CITY OF ALBUQUERQUE

September 11, 2014

**Re: I40 South and Unser Mini DMP
Engineer's Stamp Date 7-14-14 (K09D026)**

Reservoir "POND 6" Results for Run "DEVEX_1"

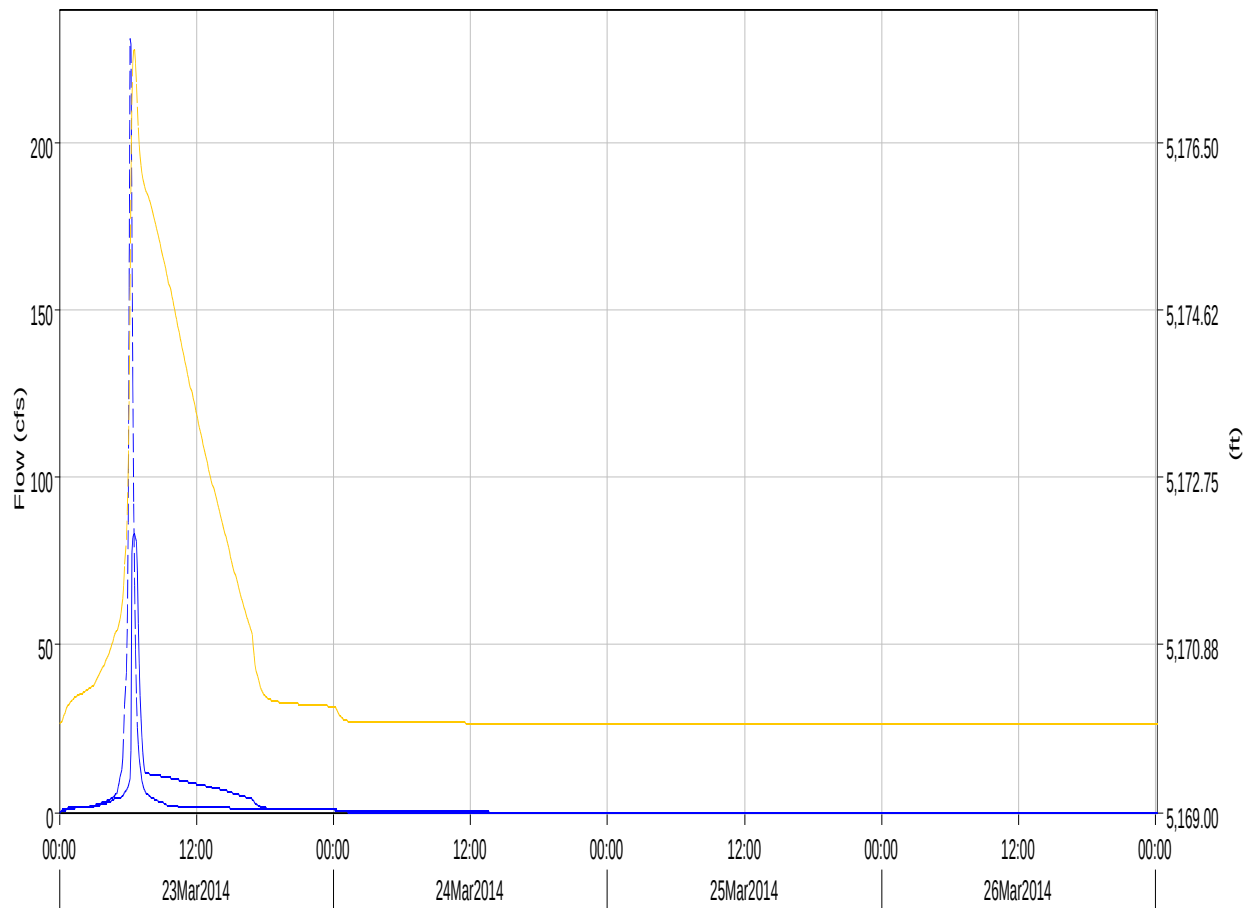
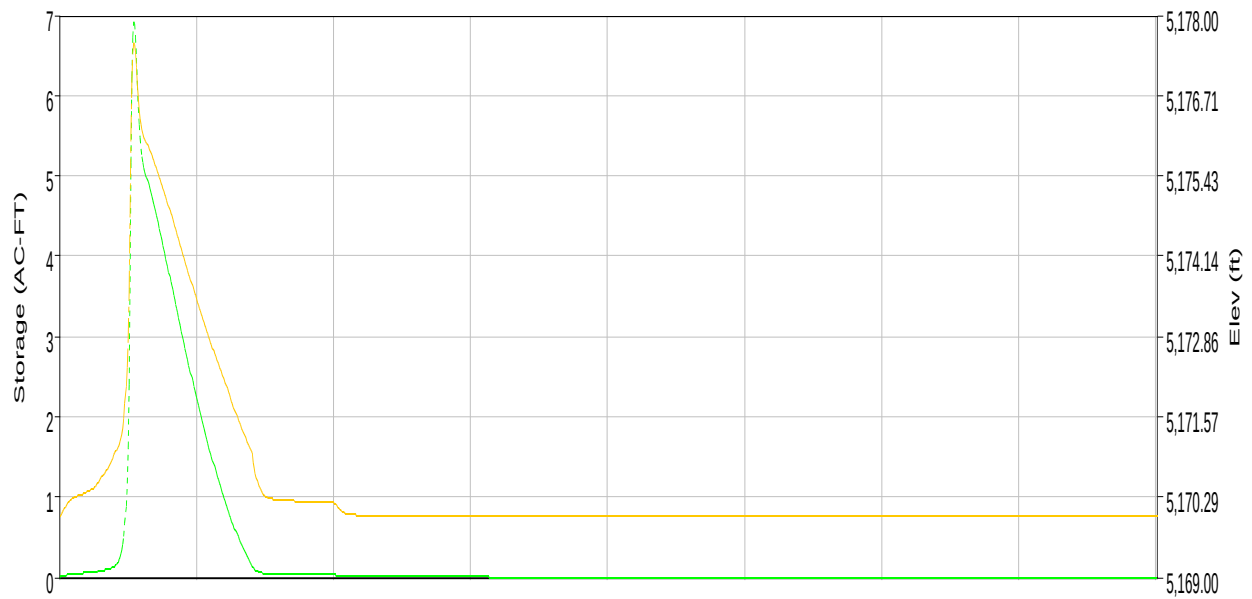
4. On the top of page 4 add the I40 basins as contributors to Pond 6.
5. The freeboard for Pond 6 is shown as 0.4 feet. Proposed runoff should be reduced to increase the freeboard to 1.0 feet.
